Please ask for: Nicola Moore
Email: nicola.moore@arun.gov.uk
Telephone: Ext 37944
Our Ref: LU/263/21/PL
Your Ref:
Date: 3rd September 2021

Application for Planning Permission

Development: The construction of a two-storey office building (Use Class E).
Location: Land At Unit 4 Hawthorn Road Hawthorn Road Littlehampton BN17 7LT

No.	Description	Date
Client:	Chico & Mash	
Address:	Unit 4 Hawthorn Road, Littlehampton.	
Project:	Proposed Office Building	
Drawing title:	Block Plan	
Project No	18107	
Date	20-12-19	
Drawn by	IA	
Drawing No	BP01	
Scale1:500@A3

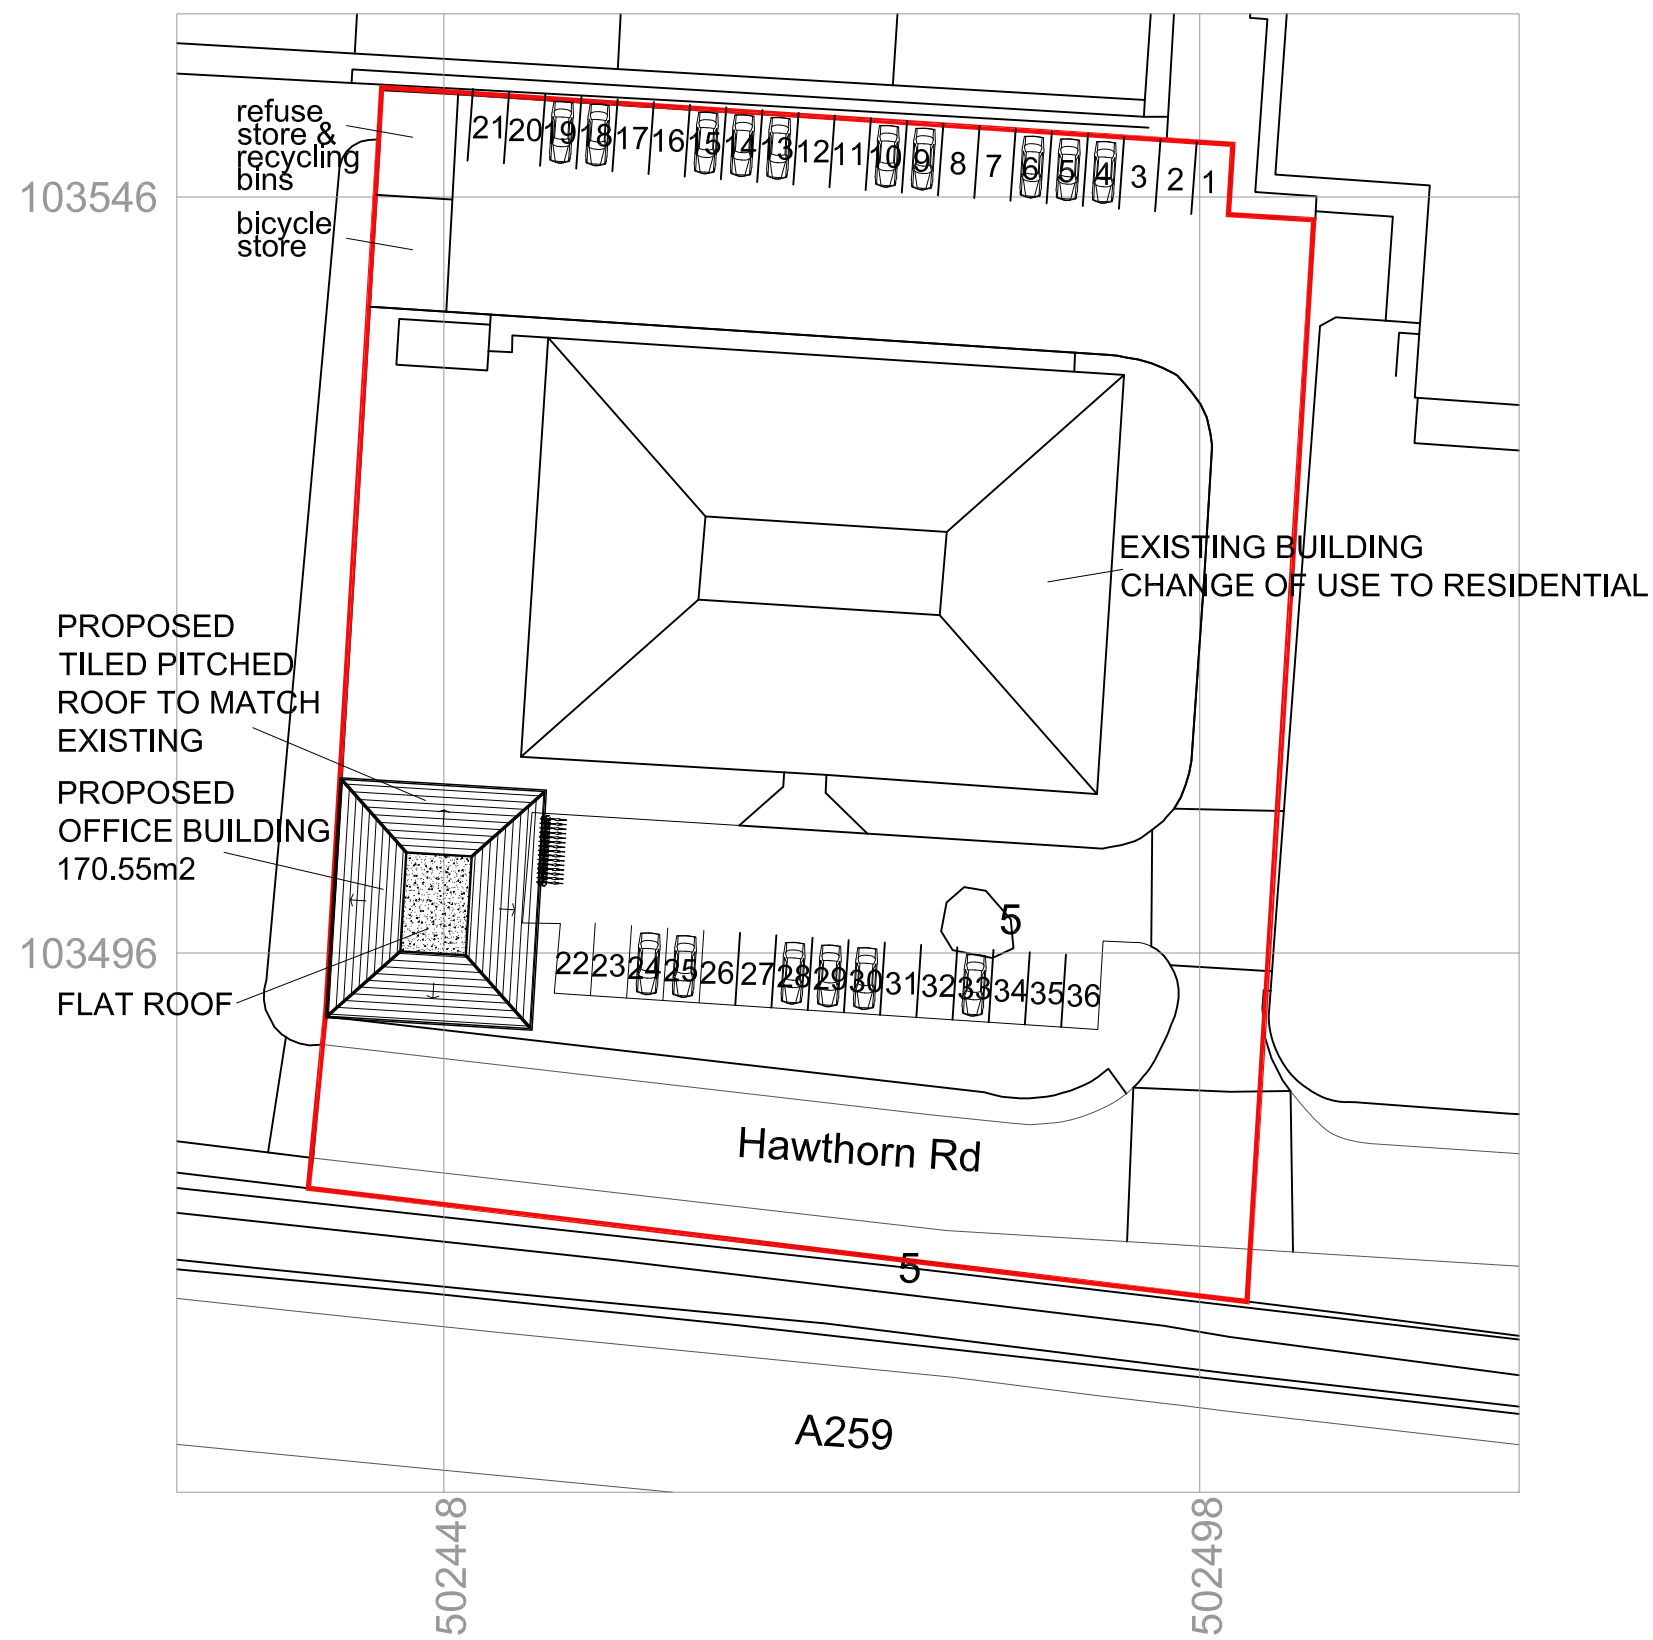
Block Plan

The Block plan should include distances to boundaries from the proposed development. Please amend accordingly and re submit. Further details of what must be included on the plan can be found in the Validation Requirements List.

No.	Description	Date
Client: Chico & Mash		
Address: Unit 4 Hawthorn Road, Littlehampton.		
Project: Proposed Office Building		
Drawing title: Site Location Plan		
Project No		18107
Date		20-12-19
Drawn by		IA
Drawing No		SLP01
Scale1:1250@A3

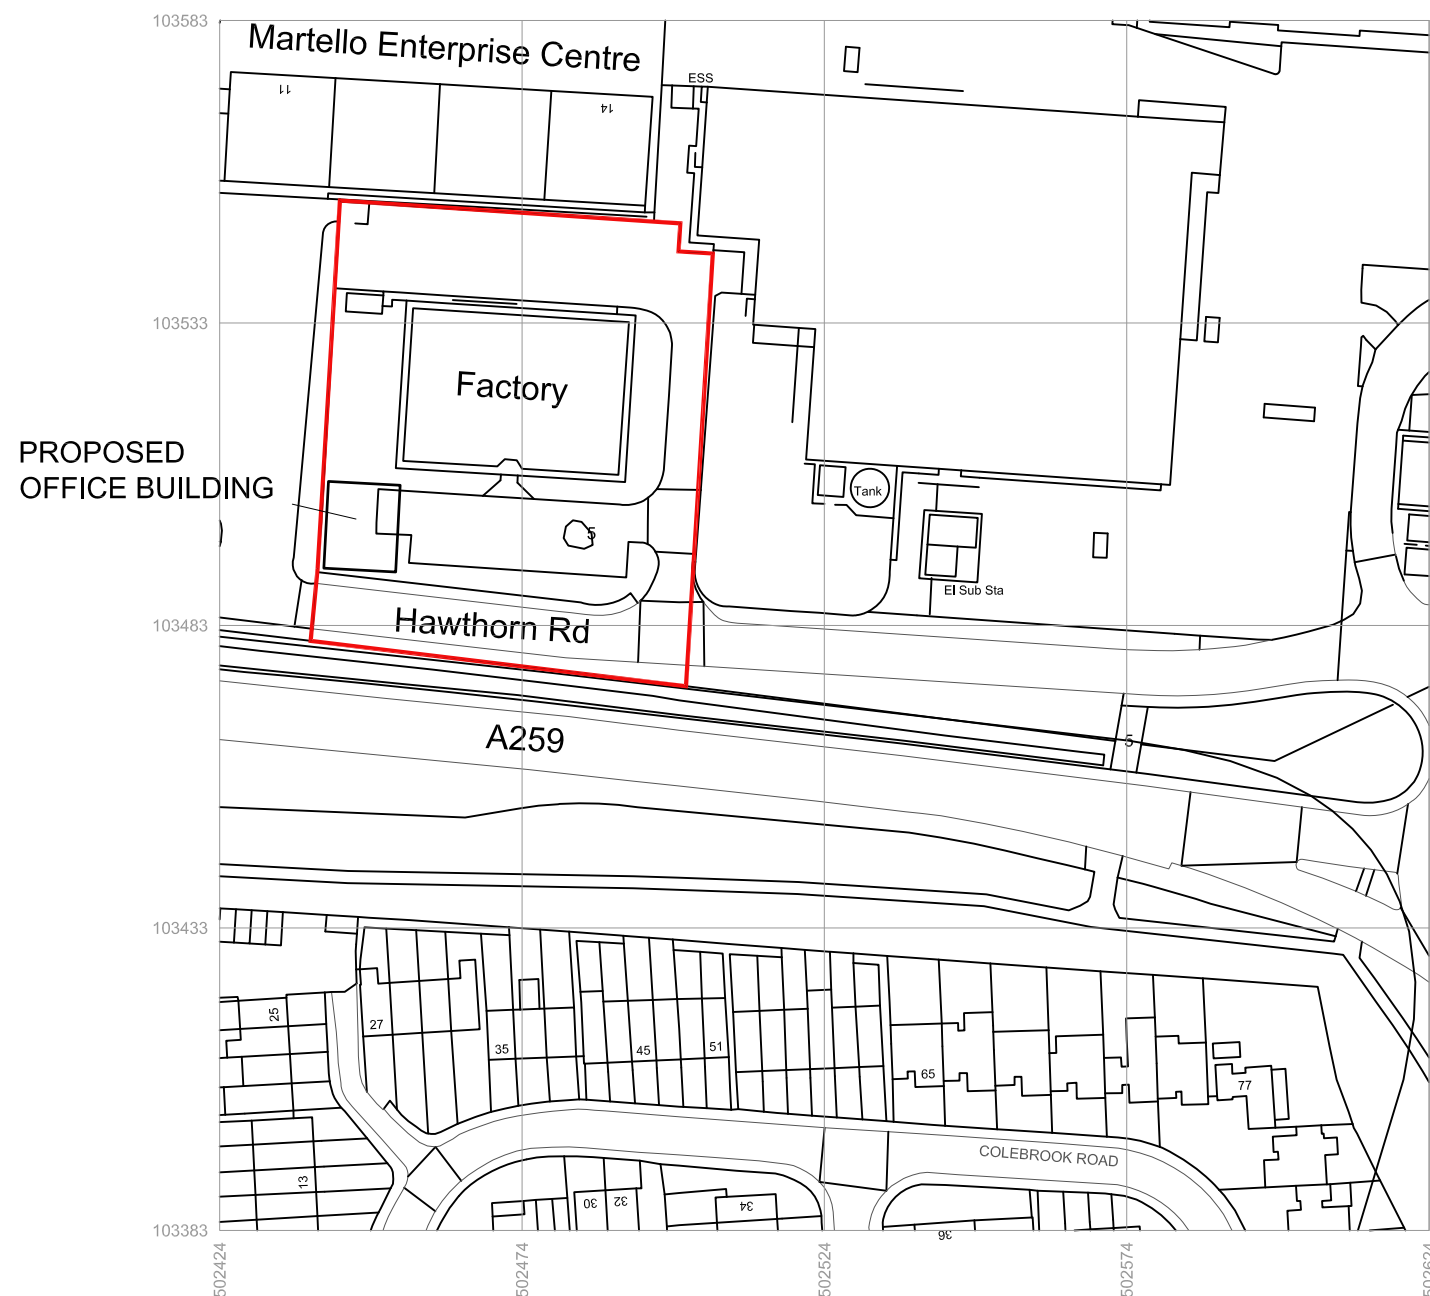
Location Plan

The Location Plan does not scale correctly at 1:1250. Please check the scale, amend accordingly and re submit. Further details of what must be included on the plan can be found in the Validation Requirements List.
